24 April 2026

WaterNSW Ref: D2026/25397

**Subject: Lake Lyell Pumped Hydro Energy Storage Project (SSI-77018220) – Response to Environmental Impact Statement**

Figure 3.11 Planned sequencing of Lake Lyell diversion, Farmers Creek infill and inlet / outlet structure

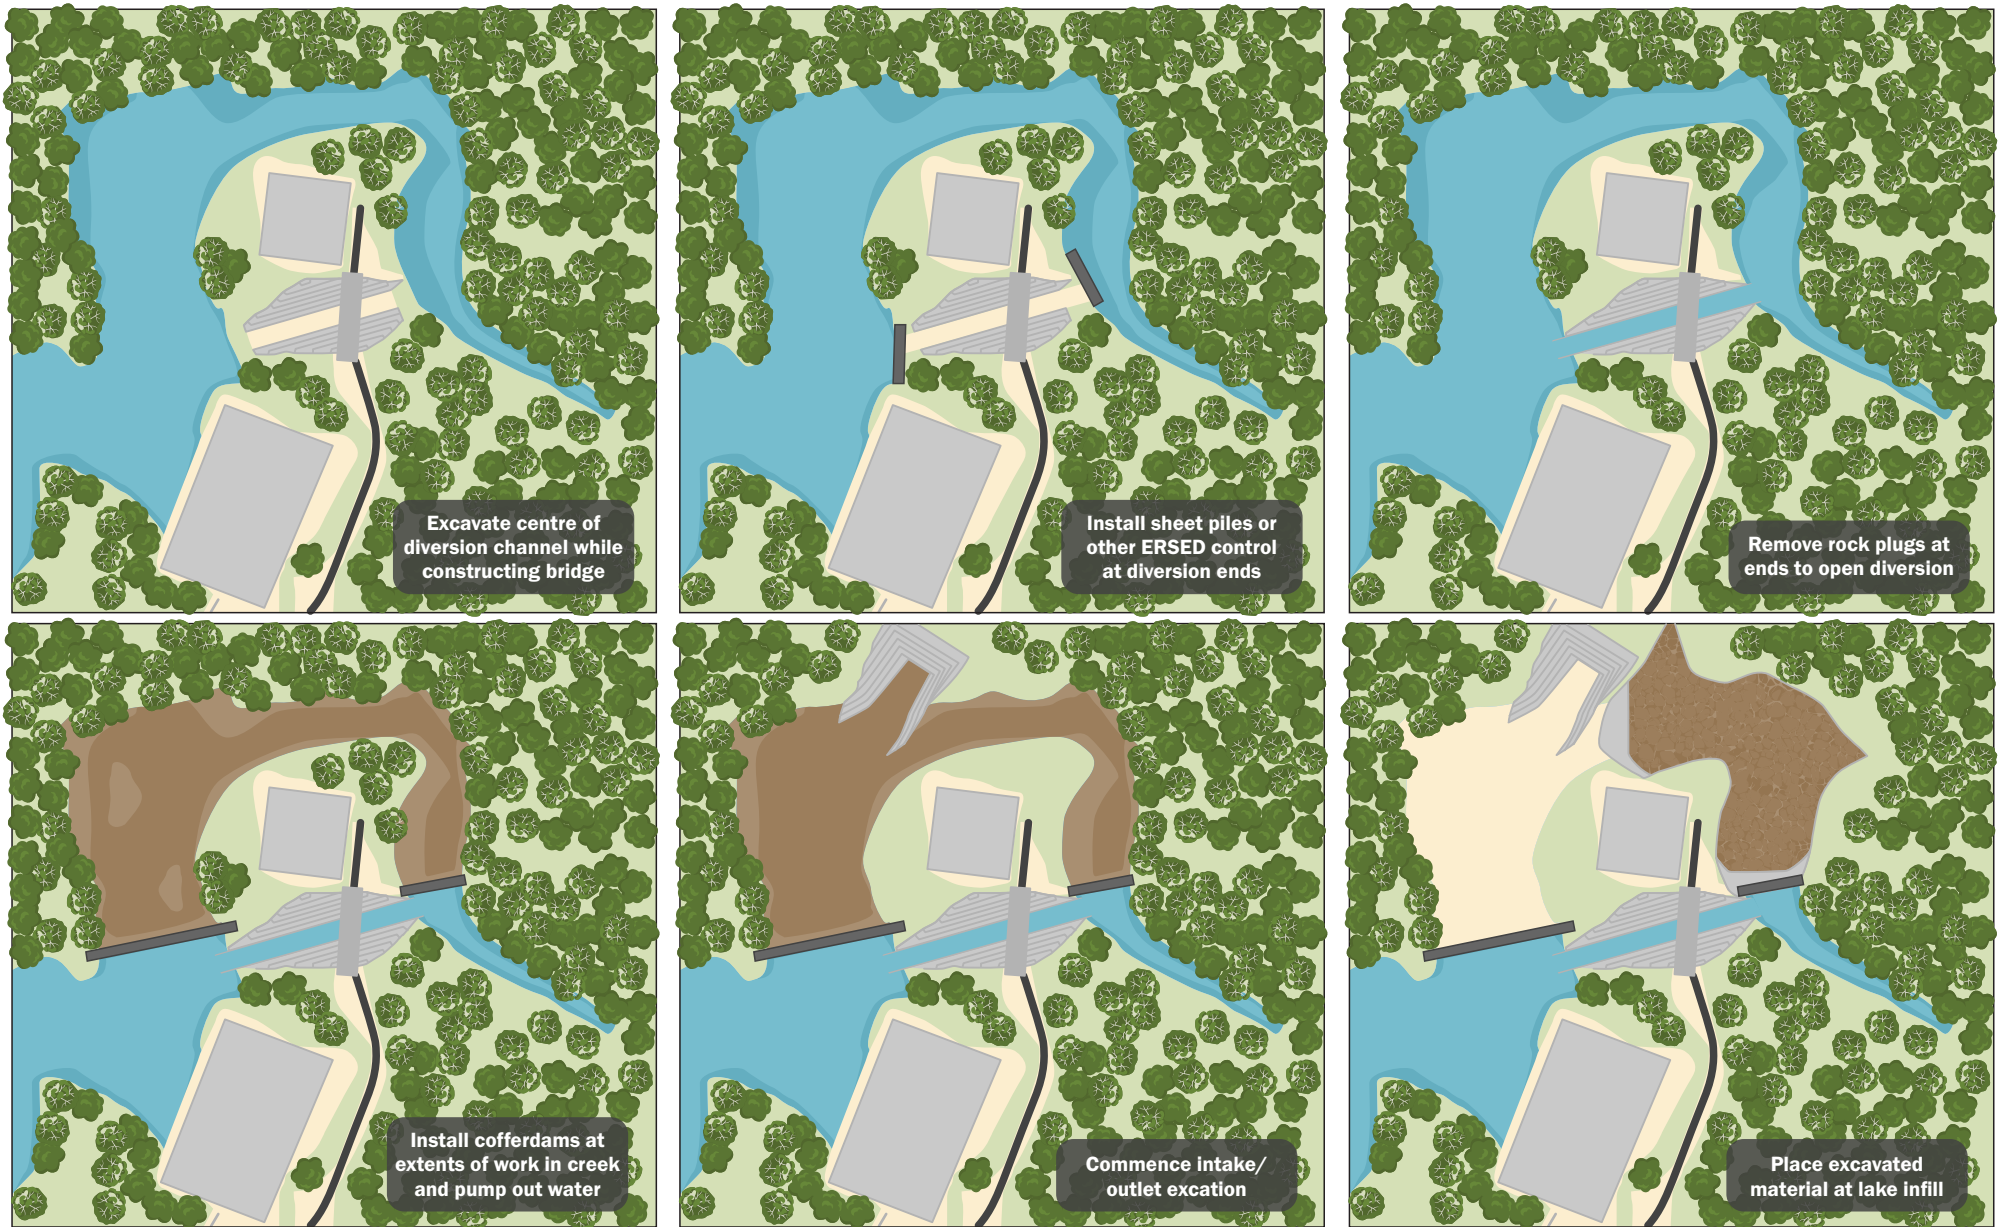
- The potential for scouring has only been undertaken for the PHES operational stage (Section 8.3 of Appendix F and Appendix G of Appendix F), and not for construction stages - specifically

the initial construction stage (Table G.1 of Appendix G of Appendix F). WaterNSW notes that water levels in Lake Lyell during the initial construction phase will be lowered to 772 m with a high potential for scouring (approximately **13 m** below FSL which is significantly lower than during operational stages). The potential for scouring has also not been assessed for the proposed diversion channel into the Farmers Creek arm of Lake Lyell during operations. WaterNSW requests that these matters be addressed in the EIS/RTS.
